Mayfield West Waste Facility-Mod-1 (SSD-7698-Mod-1)  
**Request for additional information**

Attachment 1: Department's Comments on Modification Report

## **Attachment 1 Department's Comments on Modification Report**

Figure 1 - Existing water management system

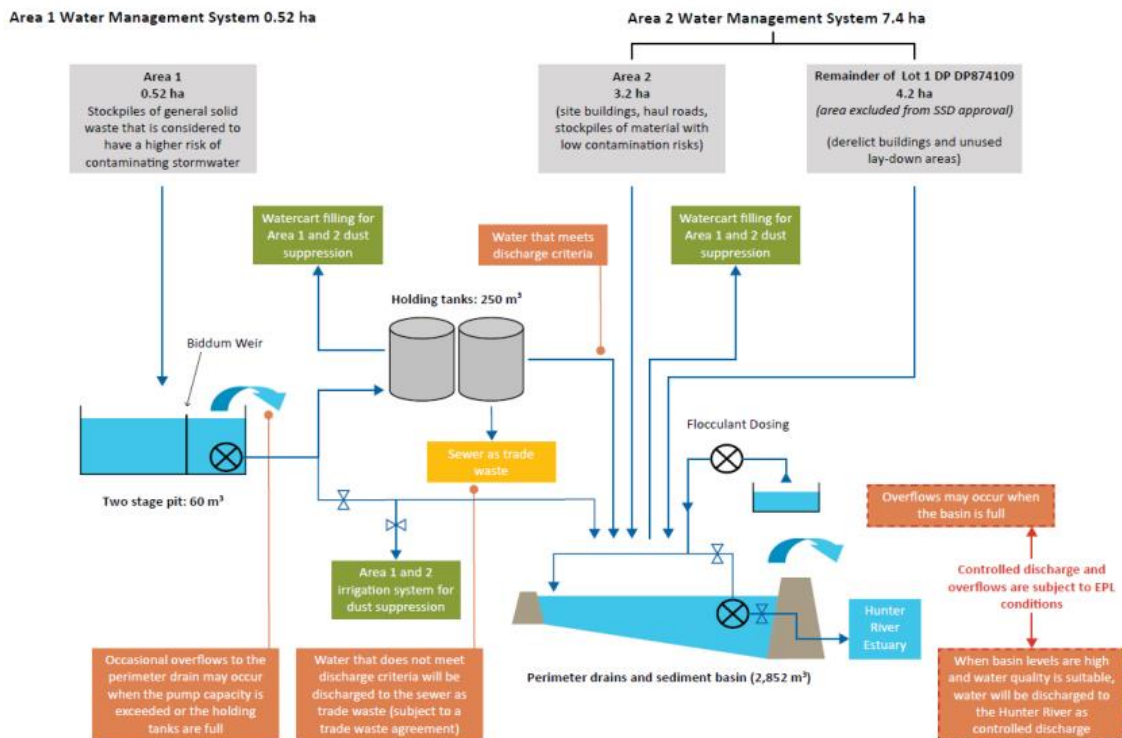
- Figure 8 shows the existing water management system for Area 1 and 2 only. The new proposed Areas would be within the Area 3 catchment in the soil and water management report. Please update the existing soil and water management report to include the new areas proposed for inclusion within the site boundary for SSD 7698.
